## Smith + Andersen

2018-10-29

**RE: MONTFORT HOSPITAL  
ORLEANS HEALTH HUB  
S+A PROJECT # 17191.001  
RESPONSES TO CITY COMMENTS FOR SPA**

Sheet Name
**OHH -
STORM
DRAINAGE PLAN**

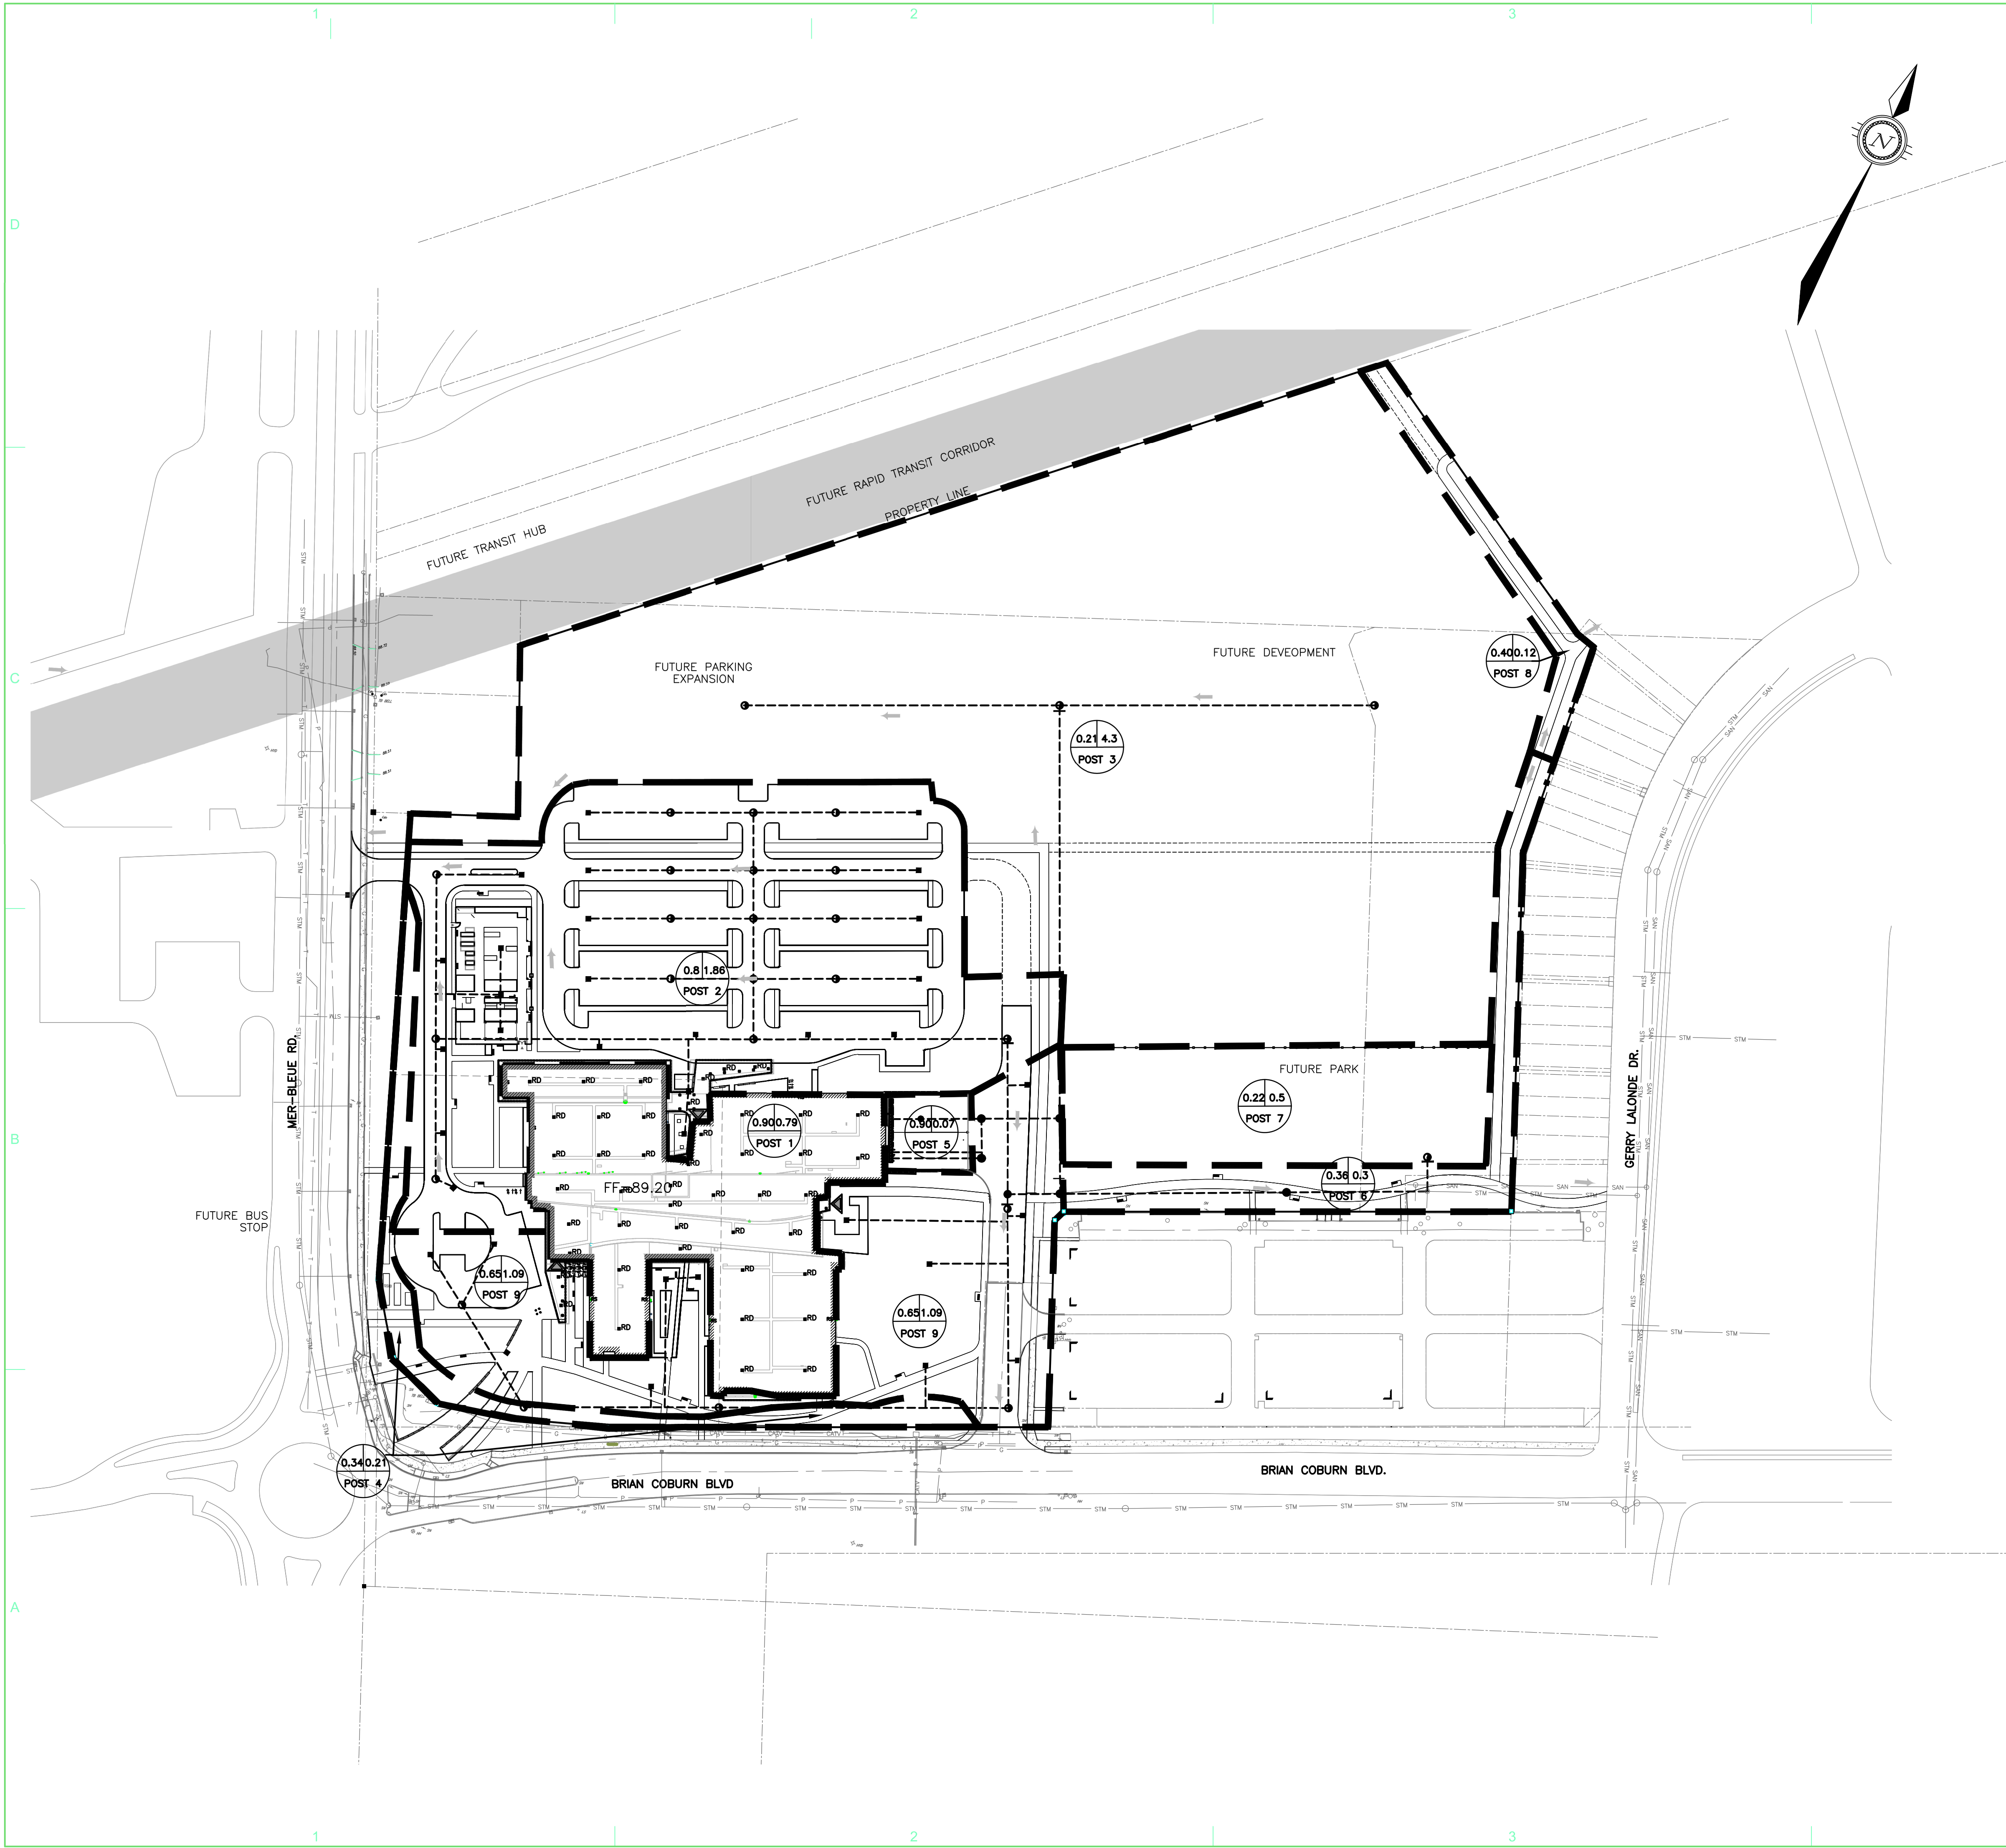
The control flow roof drains have been designed to meet the storm water management objective requirements of the 2012 Ontario Building Code Section 7.4.10.4 and in accordance with the storm water management requirements as defined by the civil engineer.
